**KIRKLEES METROPOLITAN COUNCIL
INVESTMENT & REGENERATION SERVICE**

DELEGATED DECISION TO DETERMINE PLANNING APPLICATIONS

Reference No:	2025/62/90769/E
Site Address:	22, Norwood Drive, Birkenshaw, BD11 2NS
Description:	Conversion of garage to habitable accommodation and replacement roof
Recommending Officer:	Faiza Bano

DECISION – CONDITIONAL FULL PERMISSION

Drawing Title
PROPOSED

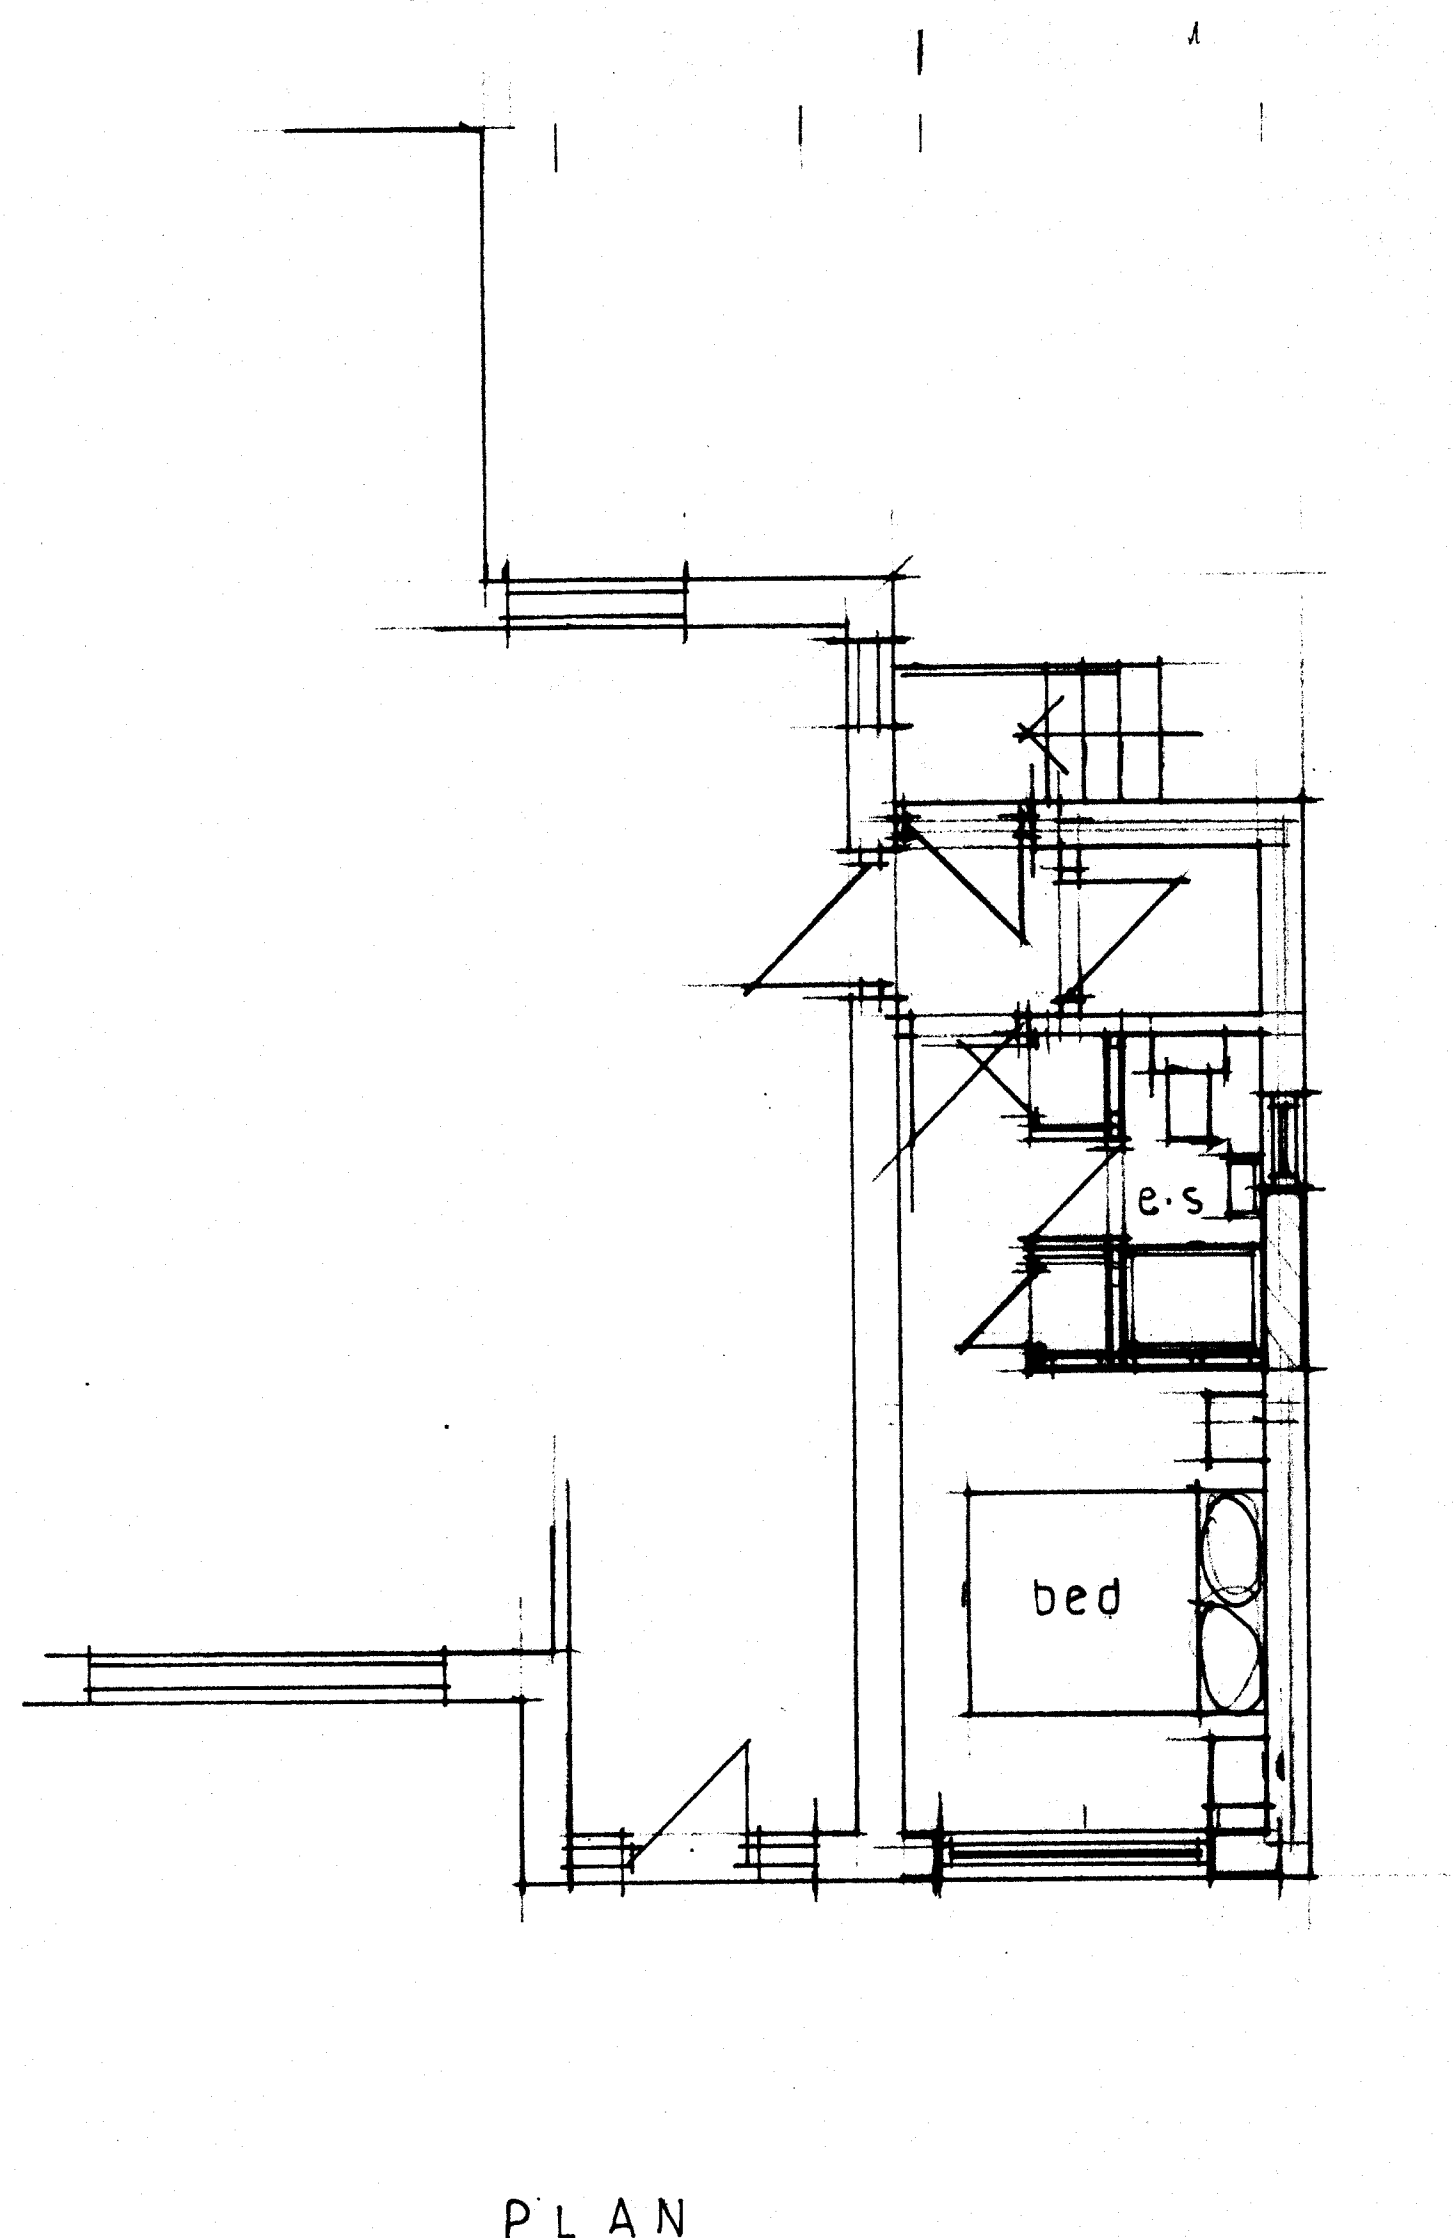
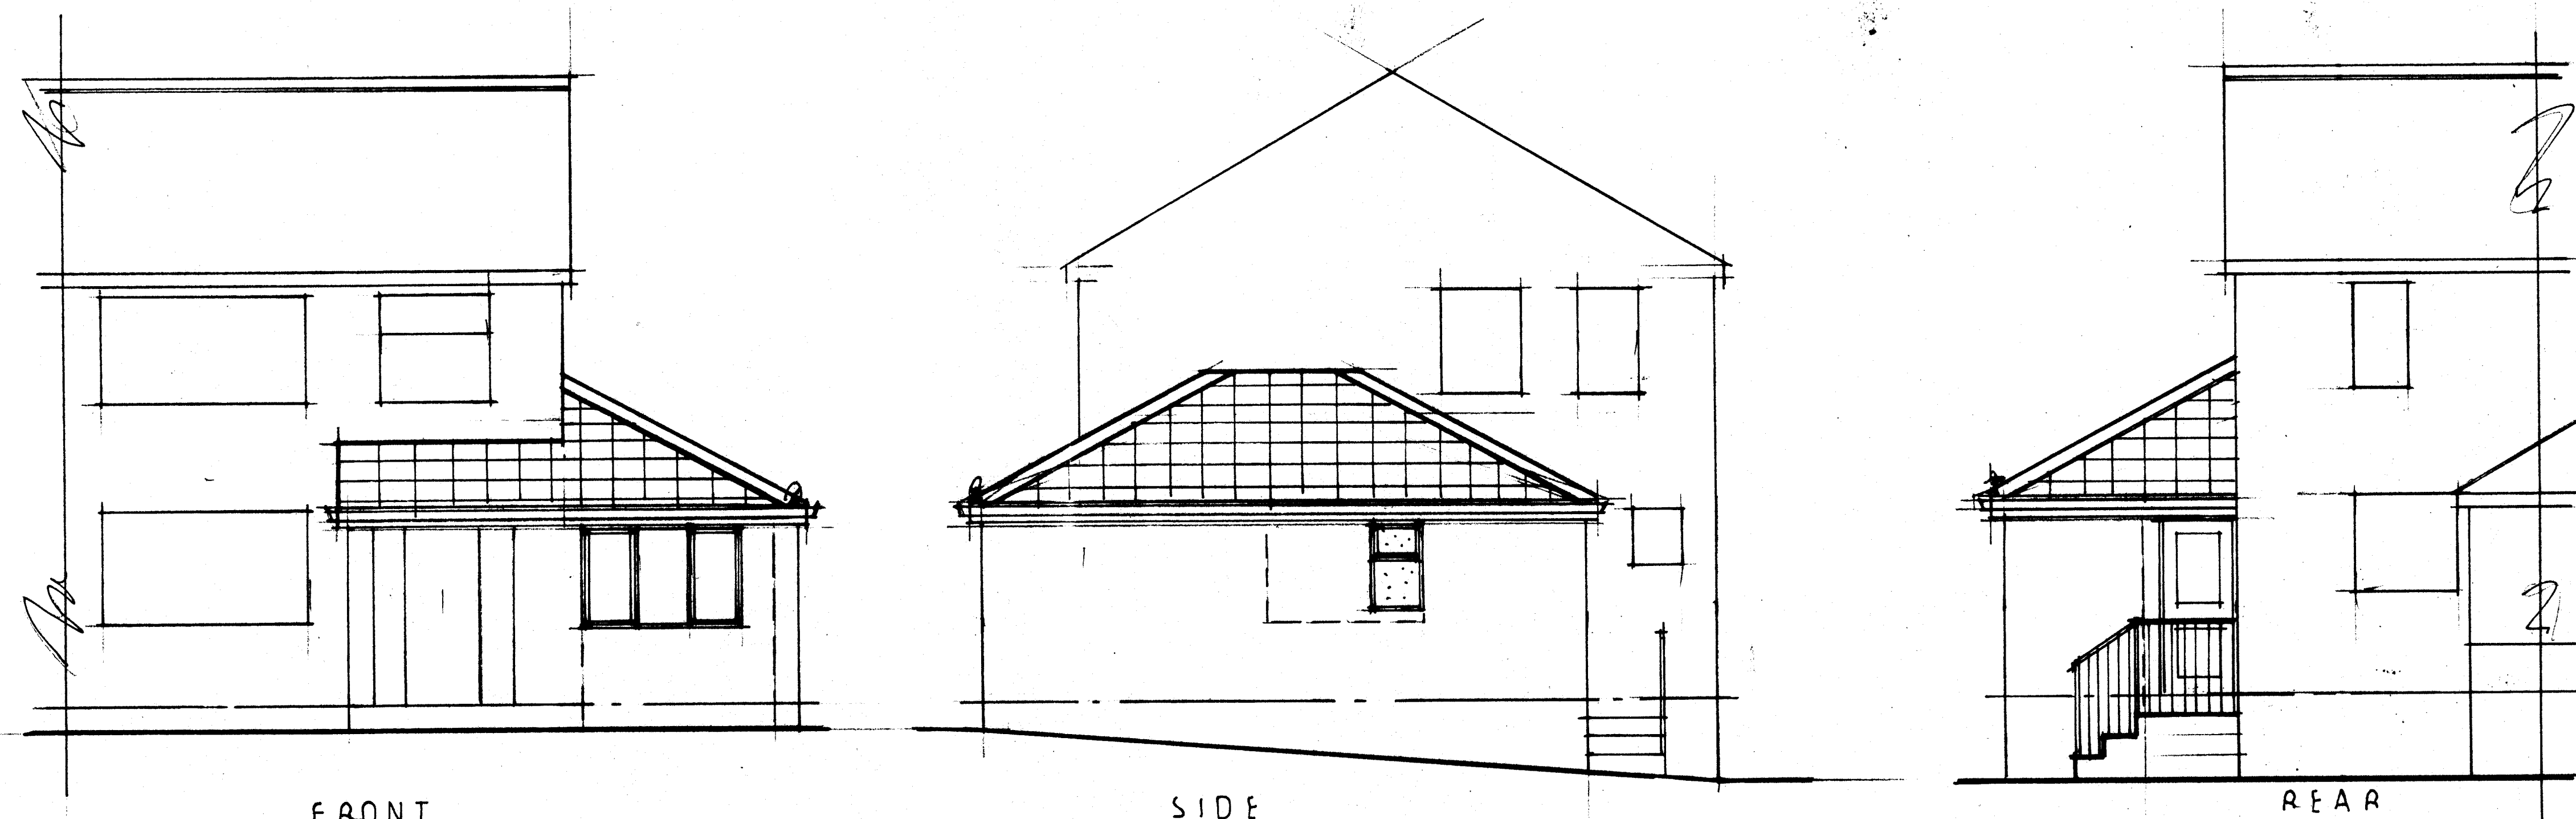
The infill reconstruction of the wall, currently occupied by the garage door, will be visually acceptable, provided that the bricks and new windows match the existing materials of the dwelling, as specified in the application and submitted drawings.

The alterations to the front to create an additional parking space is considered acceptable, retaining a small area of landscaping to prevent the space being entirely hard landscaped. This is characteristic of the street scene and would not detract.

Following a consultation with the KC Highways Development Management team, it has been determined that an additional off-street parking space would need to be demonstrated.

Amendments to the sight plan were sought and the application now proposes an additional off-street parking space, which is considered acceptable and will avoid displacement of vehicles onto the highway.
